Principal Areas of Disagreement Summary Statement

Deadline 4 on 19 September 2023

Lower Thames Crossing (LTC) – TR010032

Transport for London (TfL) – Interested Party 20035666

E. Work No. 9Z (Sheet 66) – Walking, Cycling, Horse Rider bridge over A127

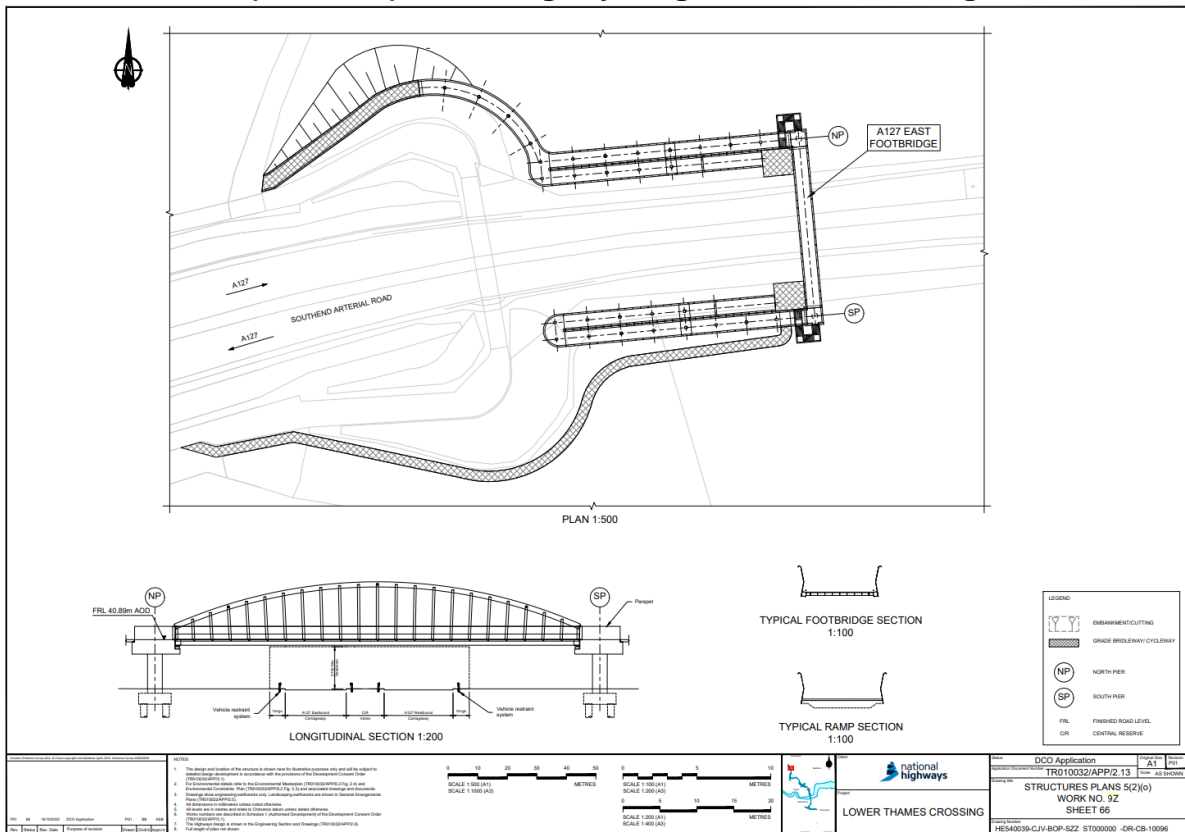
12	Walking cycling and horse riding (WCH) crossing	2.1.23	TfL needs to ensure that it has sufficient land to maintain the new WCH bridge over the A127. TfL is seeking a 5-metre-wide area for maintenance around the new structure in the absence of a detailed design confirming specific needs.	Further details of the bridge to be provided to TfL prior to detailed design stage to assess the design, construction, and maintenance implications of what is proposed, and/or protective provisions for local highway authorities to provide	Medium – could be resolved pending further discussion. This could be addressed via protective provisions for the protection of local highway authorities or

sufficient assurance. Continued dialogue should occur during the detailed design stage to ensure it can be efficiently maintained and safe.	through a side agreement with TfL.
13	Particulate matter (PM _{2.5} & PM ₁₀)	N/A	TfL no longer considers this a principal issue.	N/A	N/A
14	Nitrogen dioxide (NO ₂)	N/A	Modelled NO ₂ levels are well above World Health Organisation (WHO) guidelines, which Mayoral policy is seeking to move towards.	Consider mitigation or how Project can meet WHO guidance to reduce impact on human health.	Low – while levels are higher than aspirational guidance, they meet UK legal limit and Air Quality Strategy (AQS) objective, so the Applicant does not propose to take any further action to mitigate this.
15	Local Policy considerations	2.1.4	Project should not conflict with the Mayor's Transport Strategy (MTS) and/or adopted 2021 London Plan. The London Plan and the Mayor's Transport Strategy are important and relevant matters for the purposes of section 104 of the Planning Act 2008.	Need to address potential policy conflicts in the Planning Statement, specifically regarding assessment and mitigation of traffic and carbon impacts, and several environmental topics.	Low – Planning Statement sets out the Applicant's views of compliance with London policy, but TfL considers there to be some issues that remain, specifically with London Plan Policies T4 and S12, and MTS Policy 7.
